FG/40/20/PL

St Andrew's Church, Church Lane Ferring BN12 5HN

Replacement of existing leaded glazing in north aisle east window with stained glass, This application affects the setting of a listed building & affect the character & appearance of the Ferring Conservation Area.

ST ANDREW'S CHURCH
FERRING, WEST SUSSEX
NORTH AISLE EAST WINDOW:
AS PROPOSED

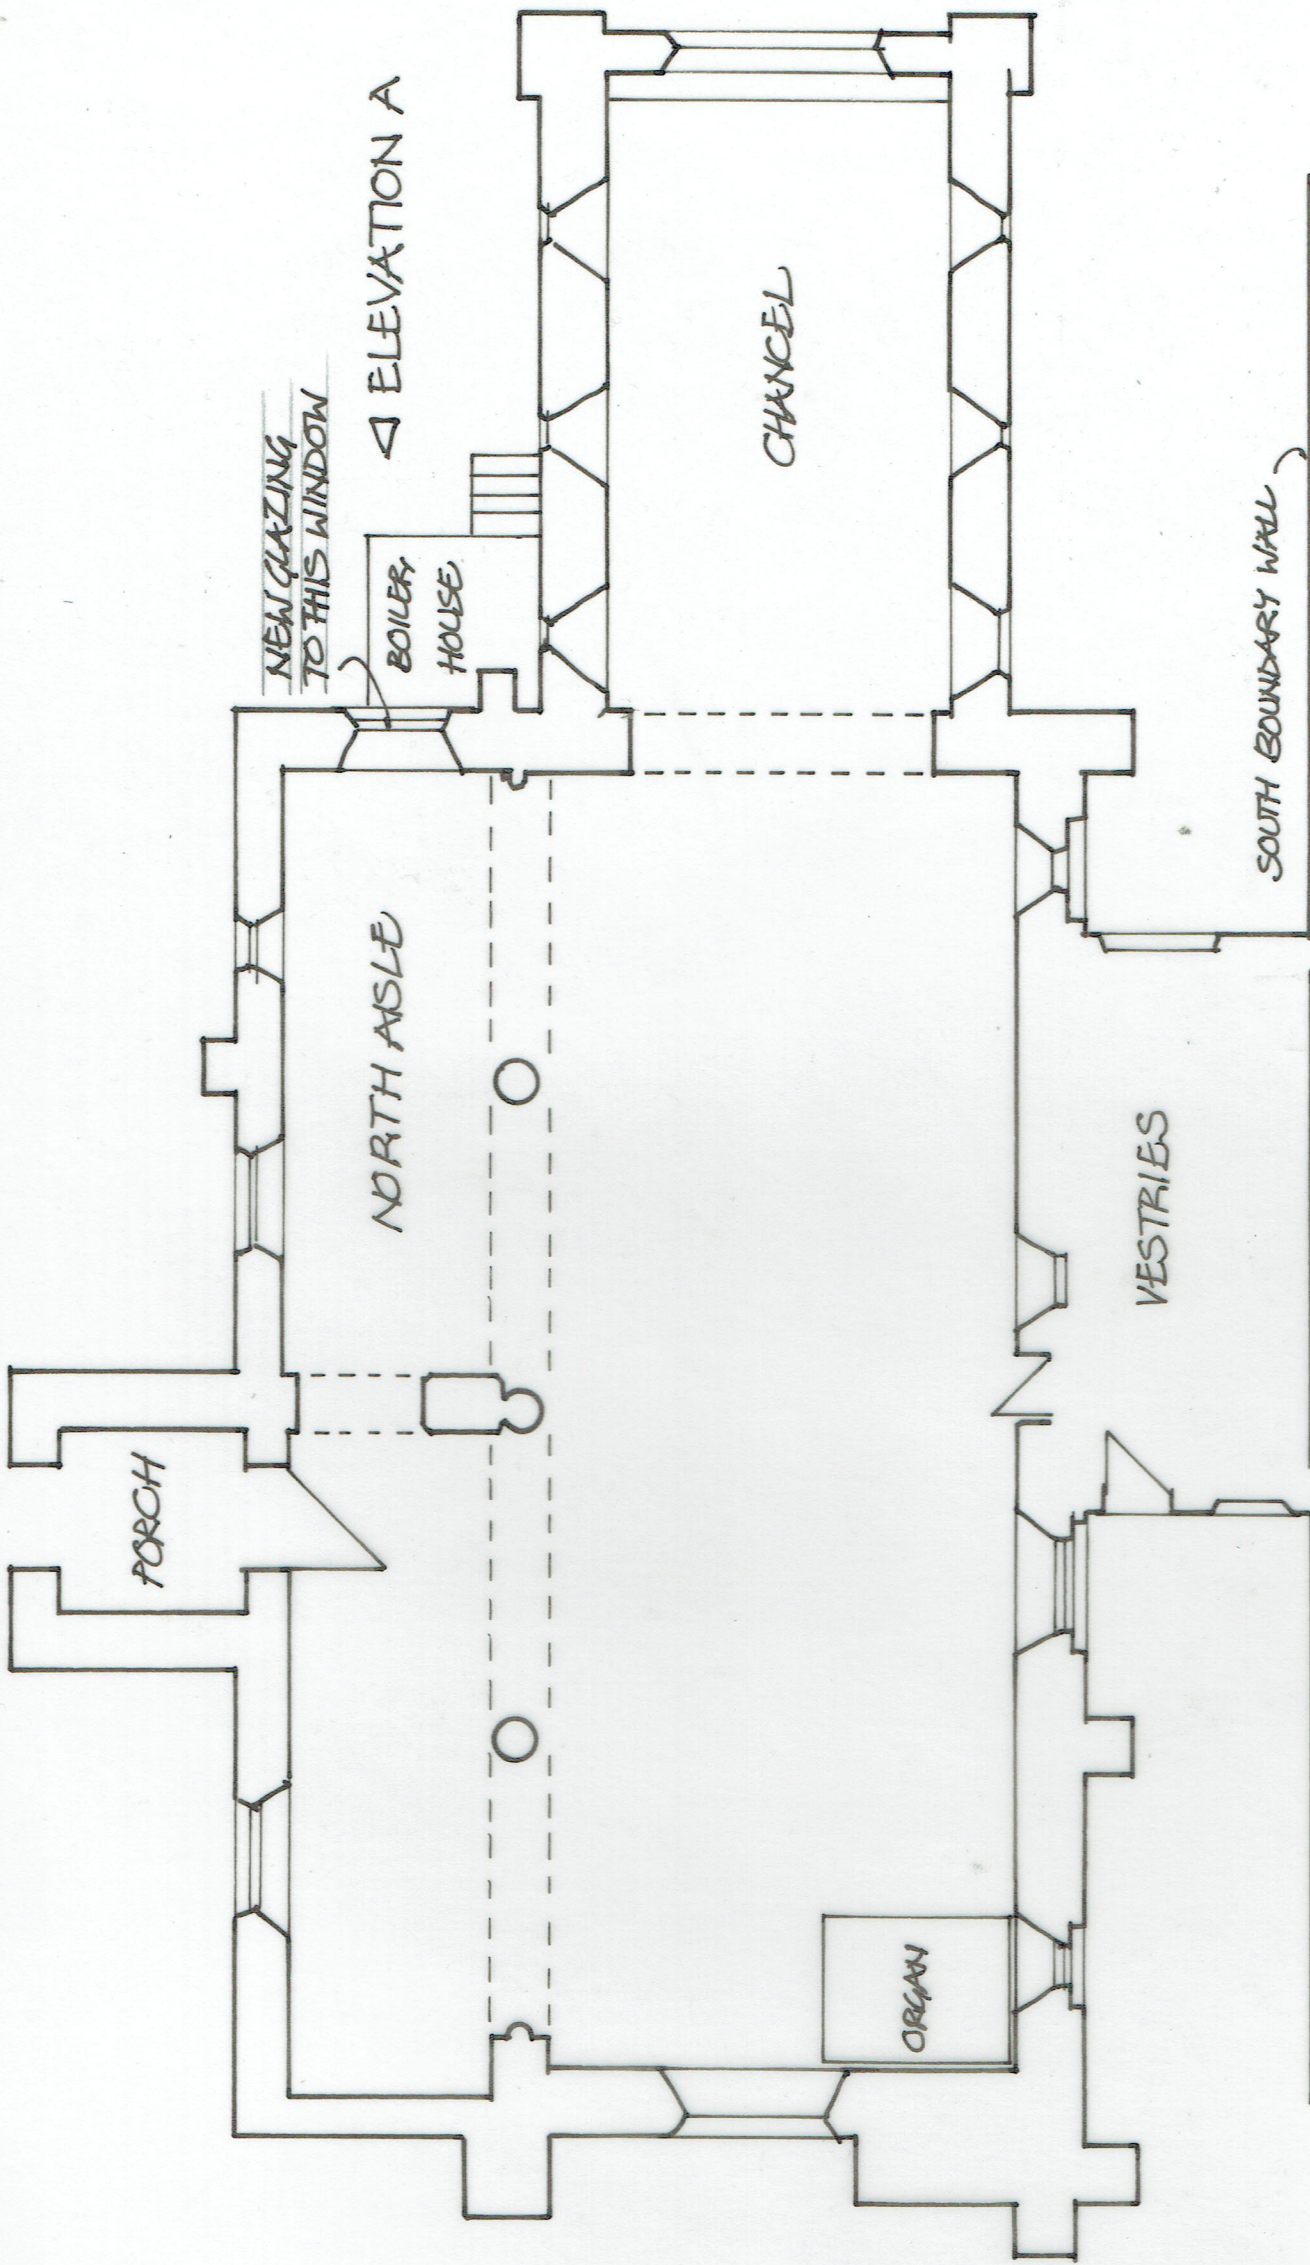
The proposed development is to remove the existing leaded glazing in the two-light east window to the north aisle, and to replace it with new stained glass. The heritage statement identifies that the existing internal ferramenta will be removed, and new non-ferrous ferramenta will be used along the lines of the leaded panel joints of the new glass, which match the locations of the existing saddlebars. The proposed glazing is contemporary in nature and would result in the removal of the existing the diamond leading/glazing which is thought to be from the late C19. However, the proposal will have no impact on the 19th C stonework to the window.

Whilst the loss of the glazing is unfortunate, the proposed design is considered to be acceptable and to complement the heritage asset. therefore, on balance, it is considered that the proposal will cause less than substantial harm to the building. It will have a neutral impact on the conservation area. The level of harm is considered to be at the lower end of the spectrum. The proposal should be determined in accordance with the relevant policies within the Development Plan, along with these comments. You will also need to take into account the contents of the Planning (Listed Buildings and Conservation Areas) Act 1990 (as amended).
